**ADC Planning Consultation
Conservation/Design Officer Response**

Application Number	Y/57/17/L AND Y/56/17/HH
Address	Wellow Barn Old Barn House Hoe Lane Flansham PO22 8NT
Description	Application for Listed Building Consent for a Detached carport
Case Officer	Mr R Temple
Date	14 th November 2017

PROPOSED PLOT PLAN

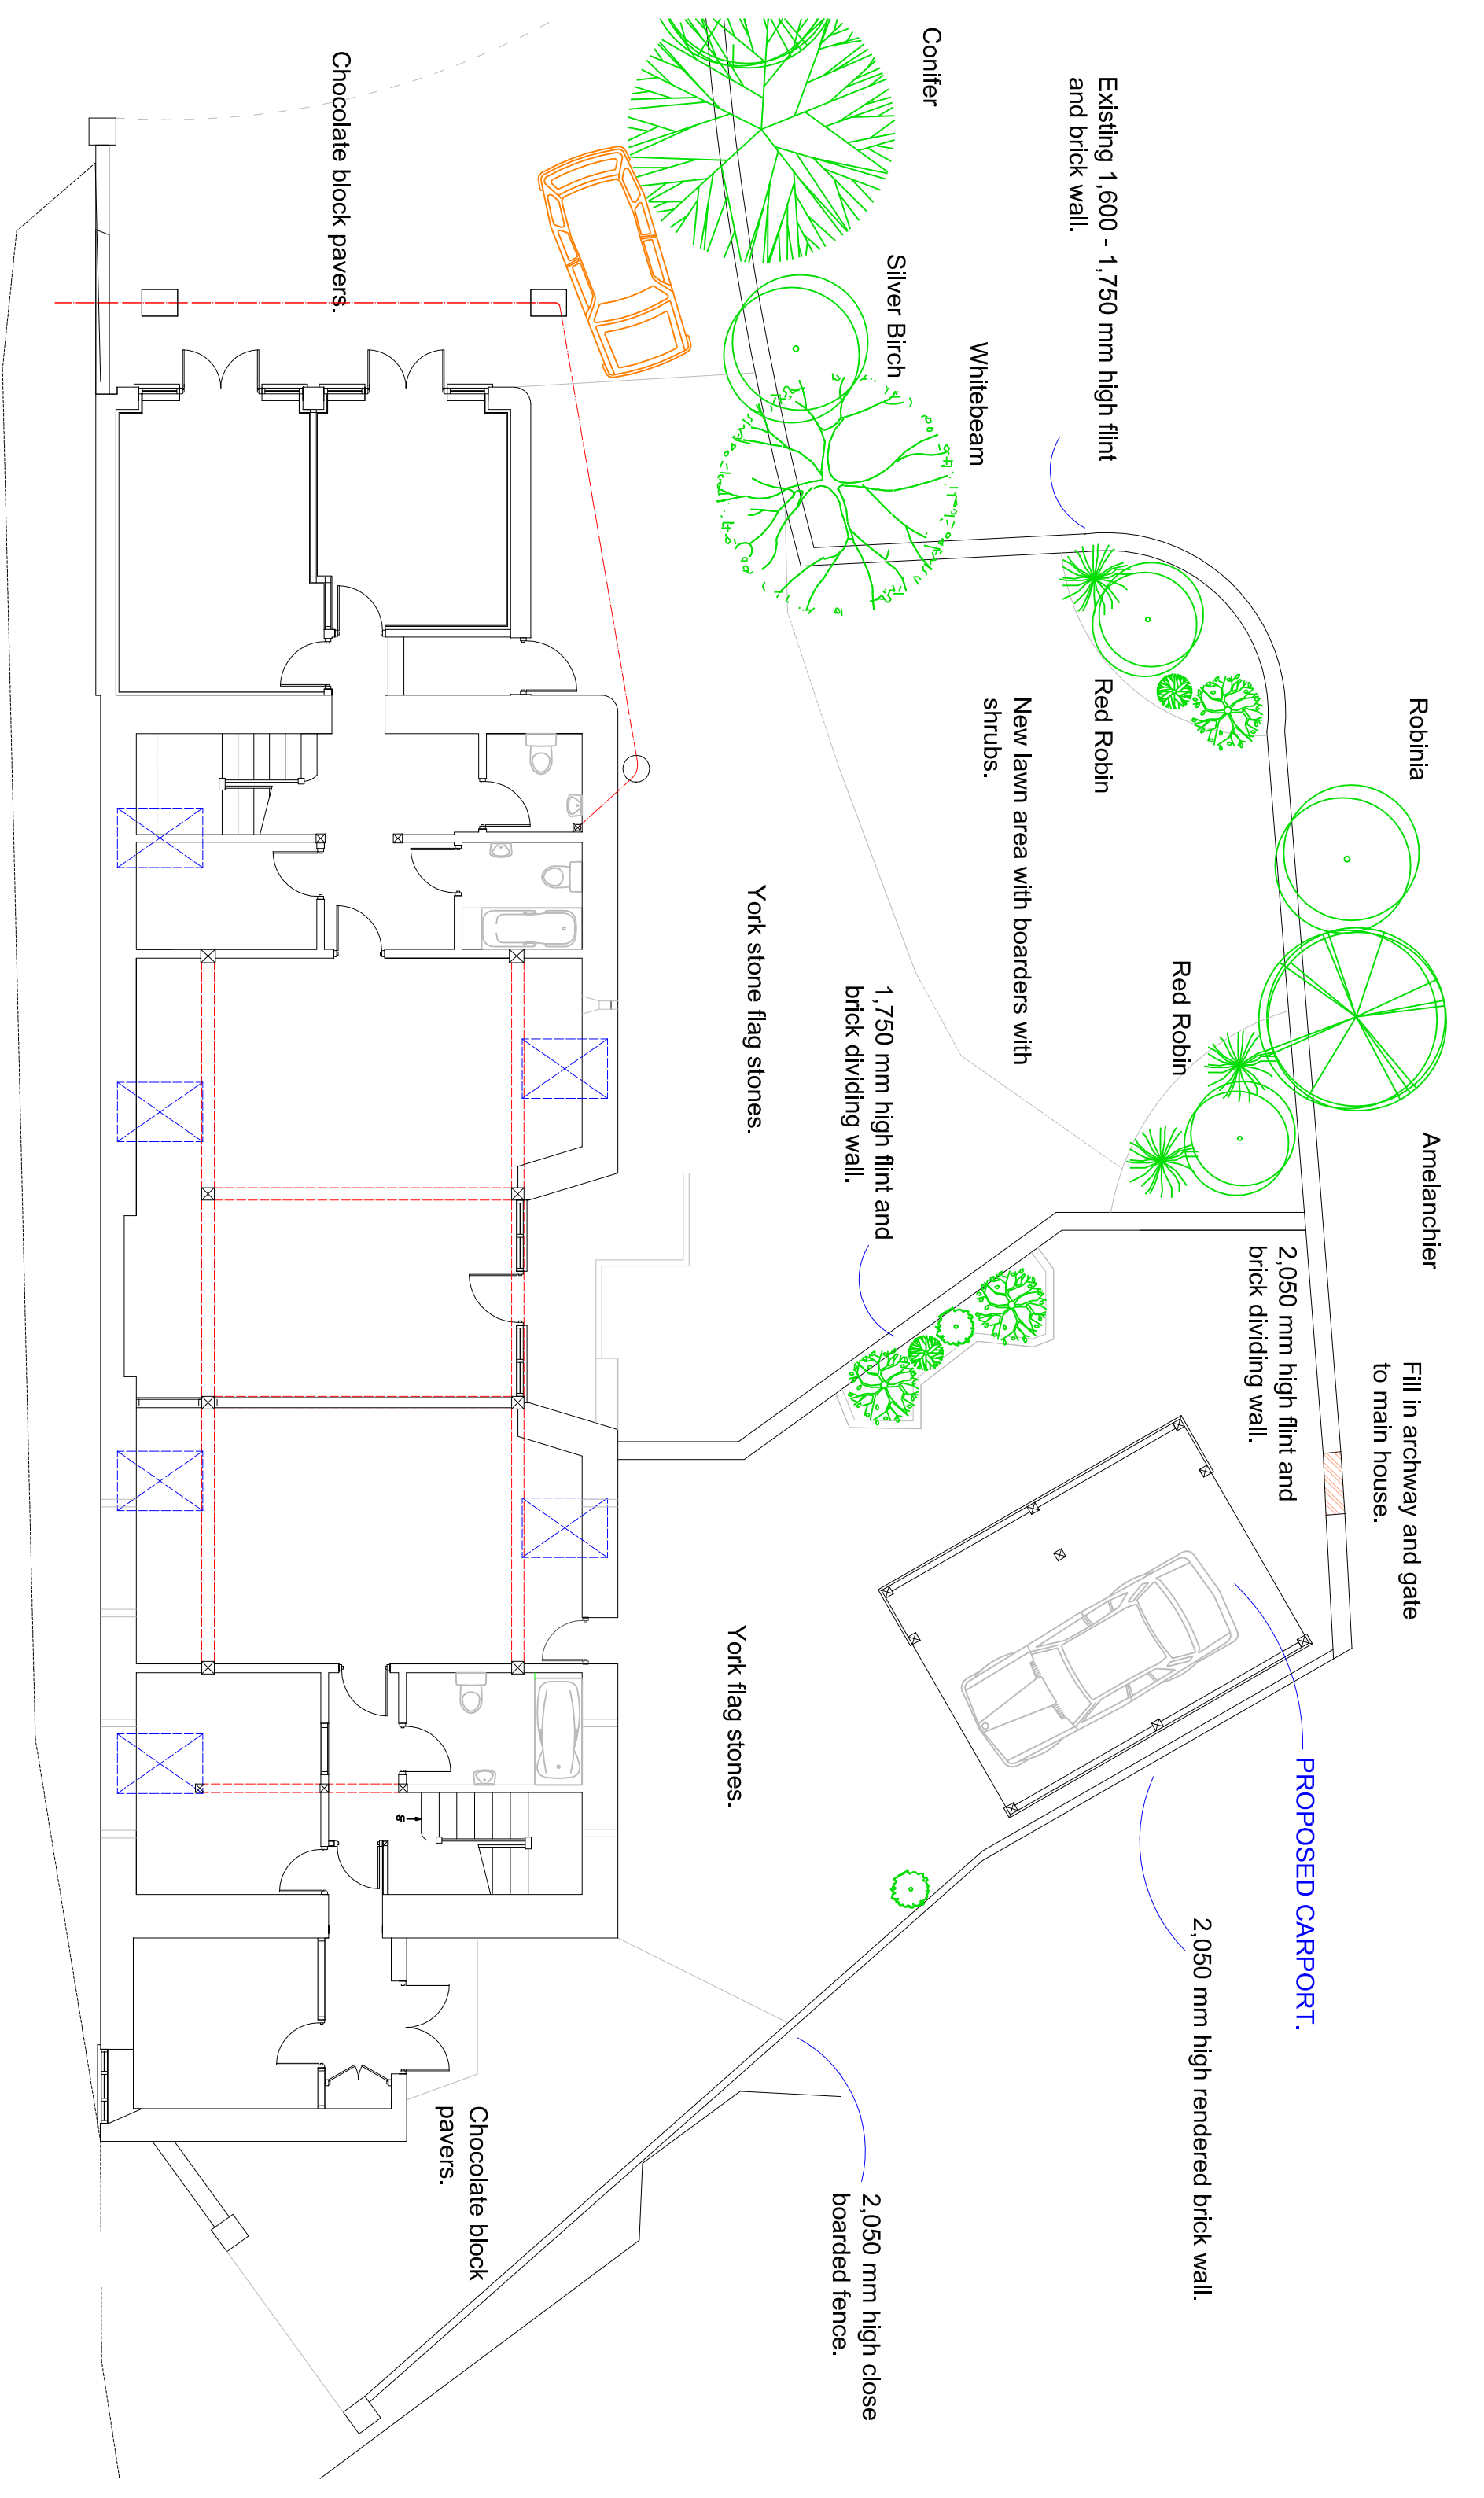
The proposal also details the blocking up of an existing, historic gate. This element represents a historic link between the house and ancillary buildings, and it is recommended that this feature be retained, and not blocked up as detailed on the submitted plans.

PROPOSED GROUND FLOOR PLAN

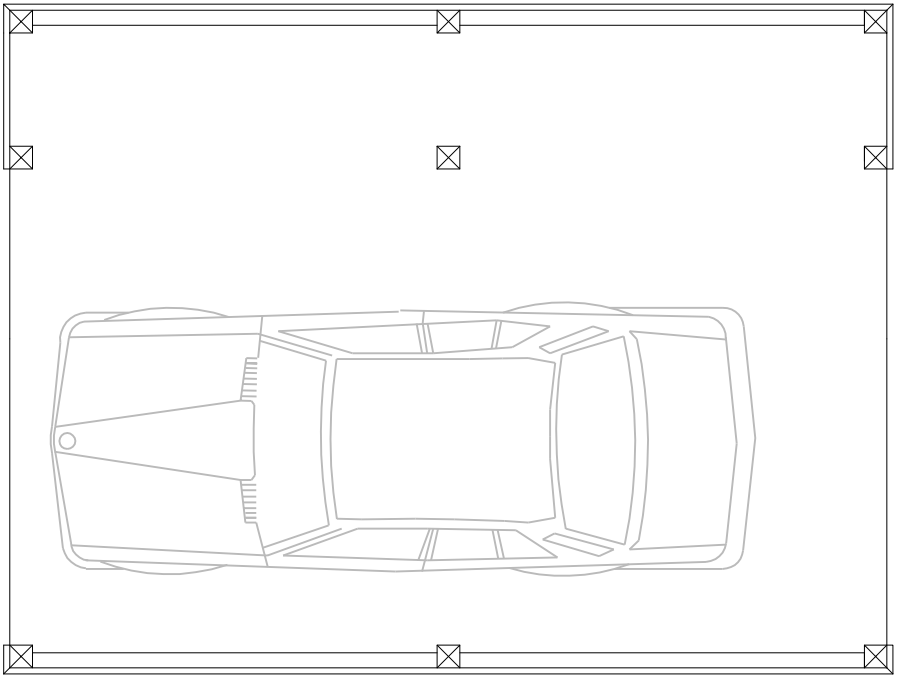
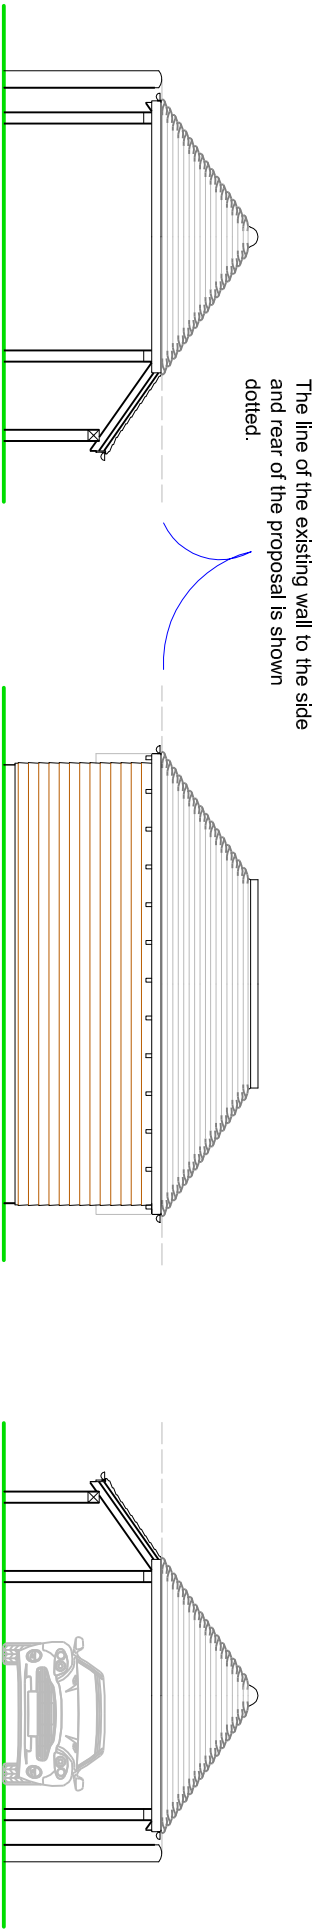
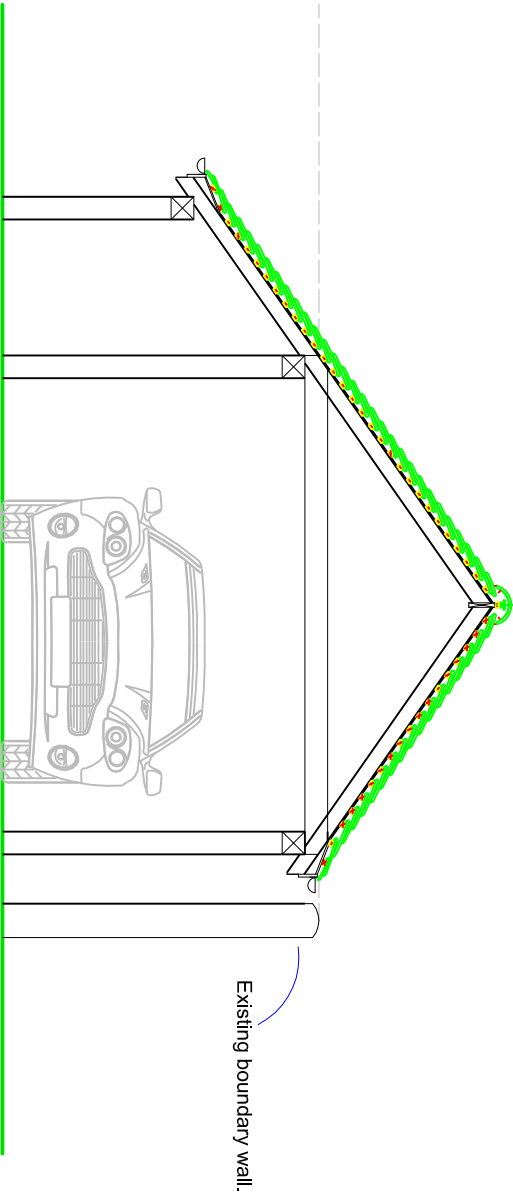
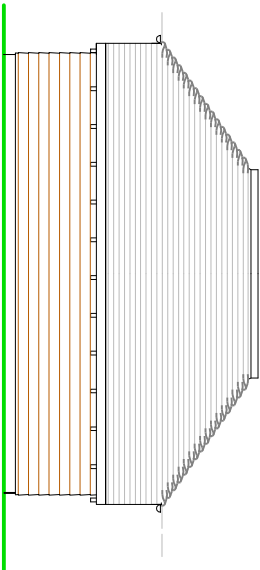
The application is for a substantial carport with integral log store.

The proposed will be dominating within a small plot, and visible from the street scene. It is considered that the development, constructed in the proposed material pallet would not represent substantial harm to the setting of a listed building.
